Consultation Response from: KC Environmental Health (Pollution & Noise Control)
2024/92862 - Land at, Abbey Road, Shepley, Huddersfield, HD8 8DY
Discharge of details reserved by conditions 3 (boundary wall), 9 (validation report), 10 (cycle parking) and 14 (highways layout) of previous Reserved Matters approval 2019/91638 for erection of 27 dwellings pursuant to outline permission 2017/92233 for erection of up to 34 dwellings
**Date Responded:
28th October 2024**
**Responding Officer:
NH**
**Responding Ref:
WK/202432789**

Recommendations
Condition 9 – Validation Report

Title
**VALIDATION LOCATION PLAN
 PLOT2 24, 25 AND 27**

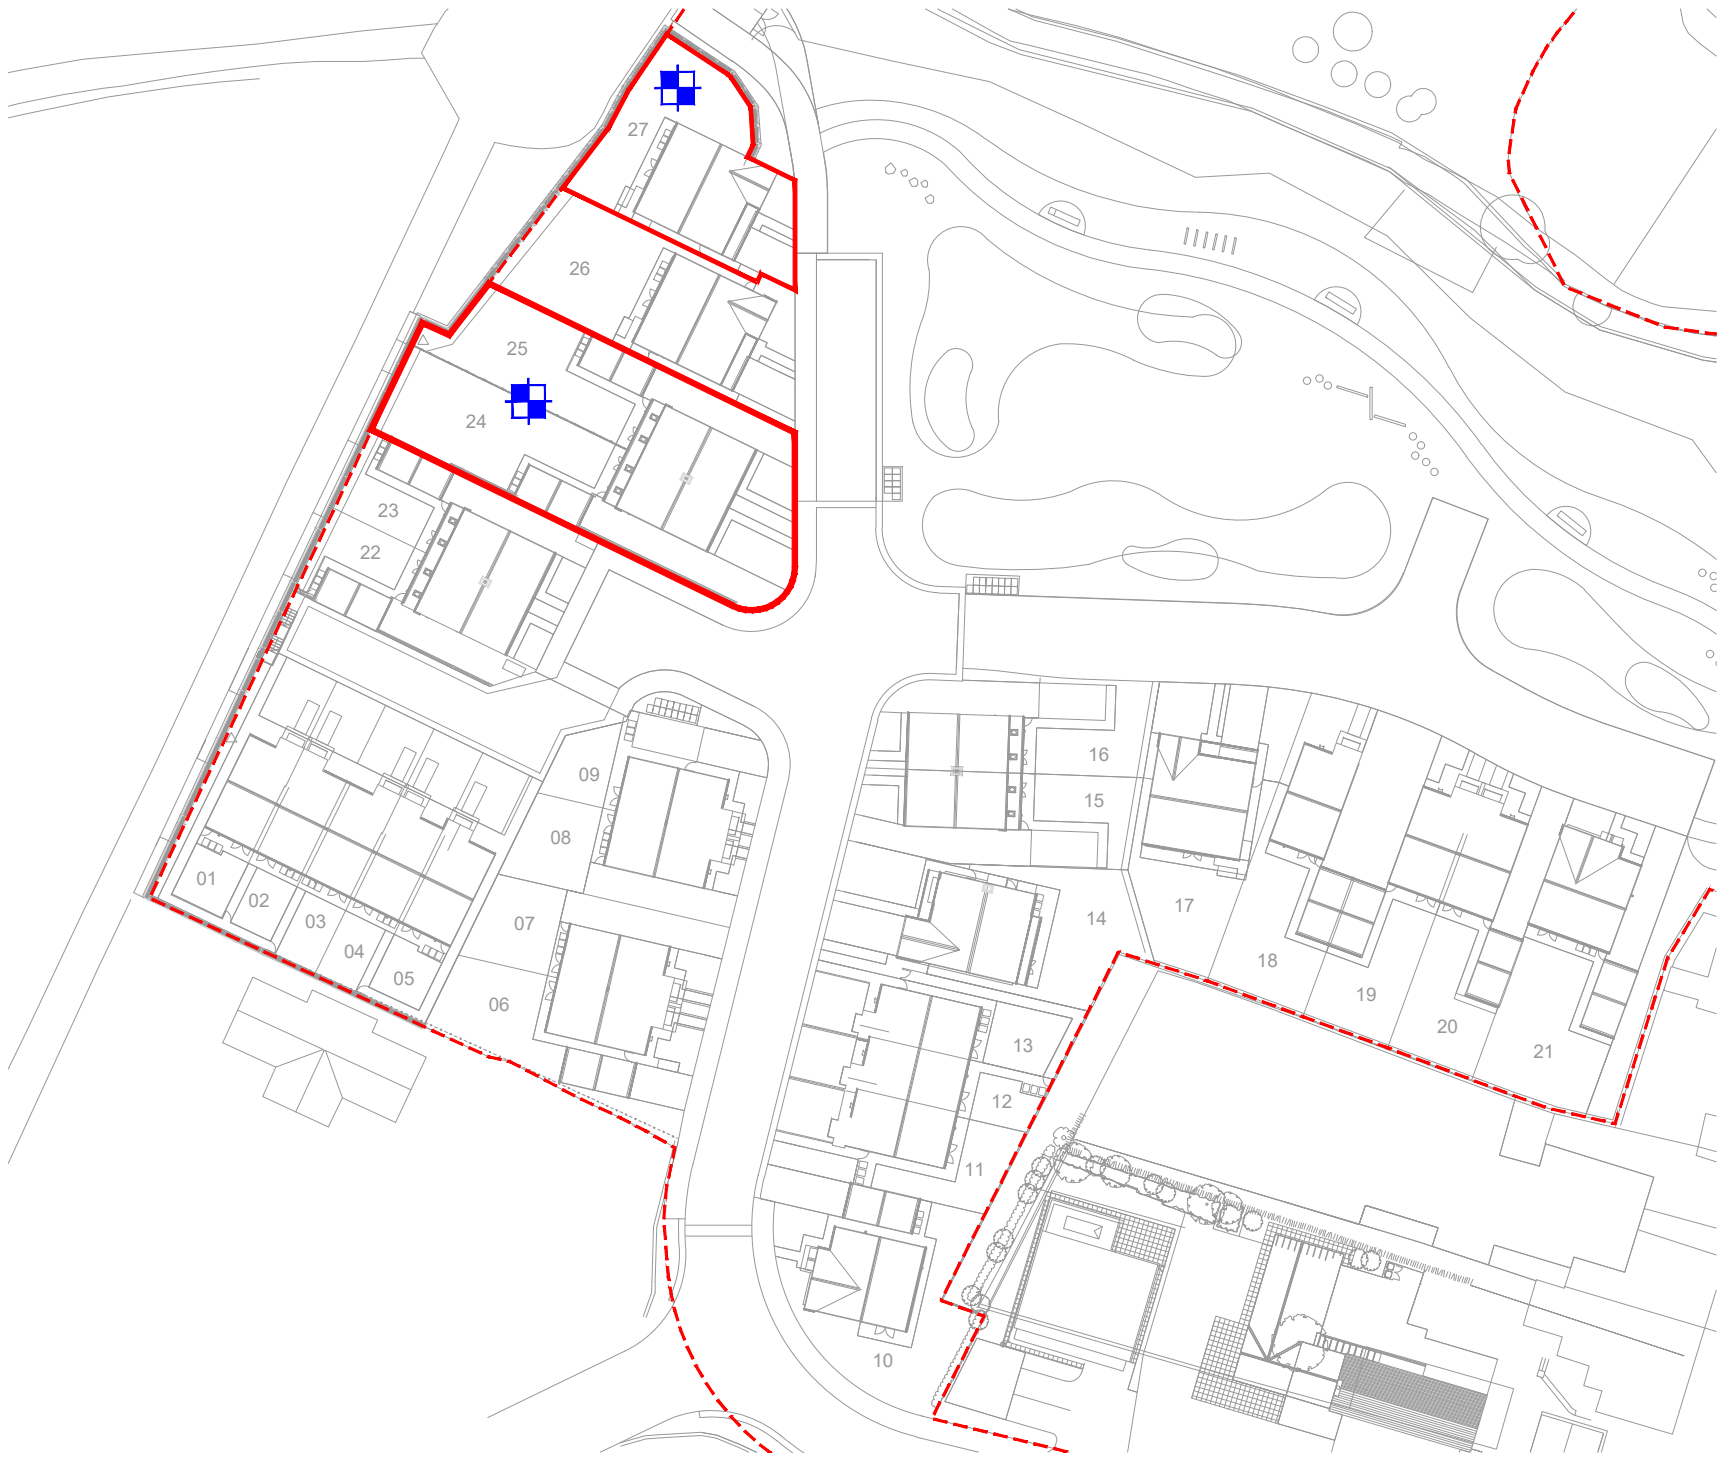
The reports include geotechnical information, which is outside the remit of Environmental Health, this consultation response therefore only relates to the land contamination aspect of the reports. We have reviewed the reports covering plots 1–13, 19–25, and 27. However, we cannot accept the documents provided as we require additional information for the plots listed. Firstly, there is a lack of documentation demonstrating that made ground has been removed off-site. Secondly, there appears to be missing supporting documents. Although there are references to additional documents that verify the suitability of materials for reuse on-site, we have not been provided access to these documents. Lastly, some photographs do not provide adequate evidence of the no-dig layer.

We do not accept the six documents provided and recommend that Condition 9 remain until further notice. Additional information is considered necessary.
